From: [David Young](#)
To: [Kelly Bacon \(CD\)](#)
Subject: Miscellaneous SEPA Applications - SE-20-00003 Brown & Jackson
Date: Friday, August 28, 2020 10:14:56 AM

I would like to comment on;Miscellaneous SEPA Applications - SE-20-00003 Brown & Jackson.

The proposal for the construction and operation for two open ponds to hold biosolids/human waste, include the statements

**BROWN & JACKSON**  
 Land Application Site  
 Preliminary  
 Site Map  
 Kittitas County  
 Washington

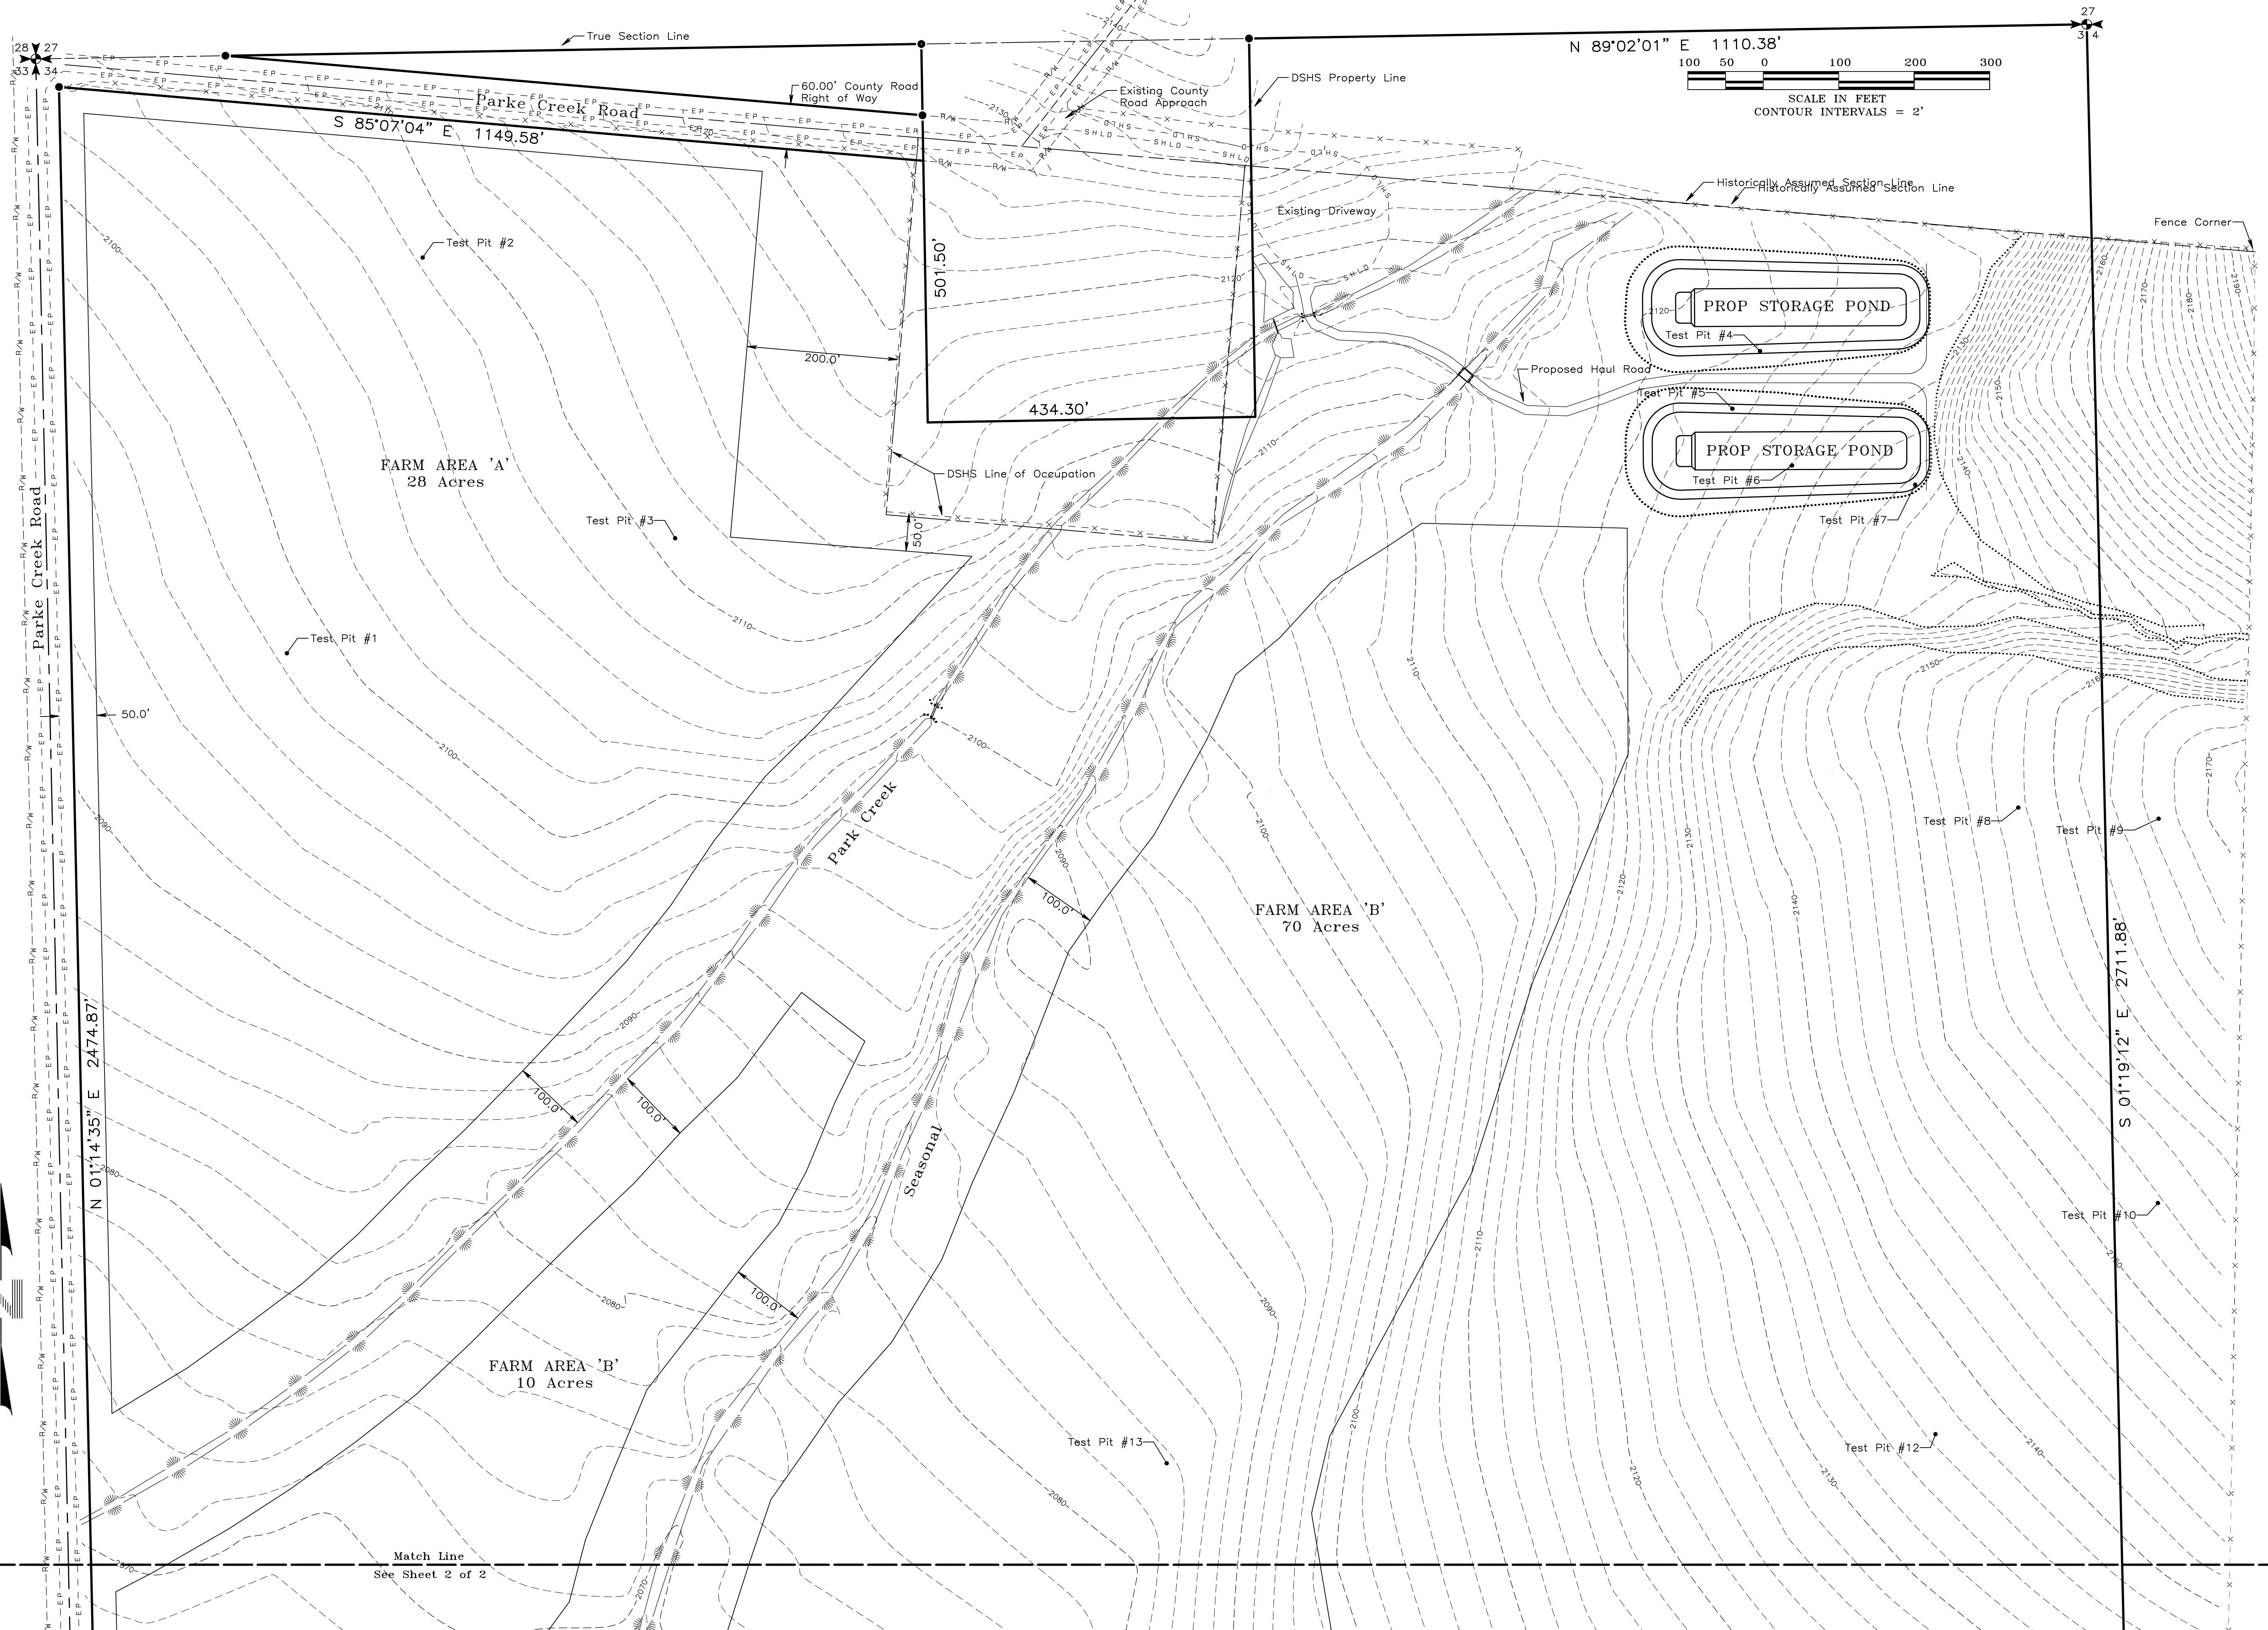
“ Additionally, the stored septage, and land applied septage can give an odor.” and
“It is not expected that any waste materials will enter surface waters.”

Odors, will be produced by the bacteria acting on the waste contained in the ponds, also odors will be present during and after land application of the waste from these ponds. Although efforts to minimize odors are to be attempted, the amount, and strength of odors from these sources cannot be ascertained until this project is completed and in operation. Air movement such as a breeze, or air, cooling in the evening and flowing downhill to lower areas will carry odors with them. Odors produced on site cannot be contained on site as they will move with the air to surrounding areas including home sites.

The possibility of contamination of surface waters can happen as storm rain water, and/or snowmelt events have a way of eventually exceeding expectations of planners and builders. Currently there are no stated plans for future expansion of this project, but as there could be future expansion of this project once permitted, the problem with odors and possible contamination of surface waters would increase also.
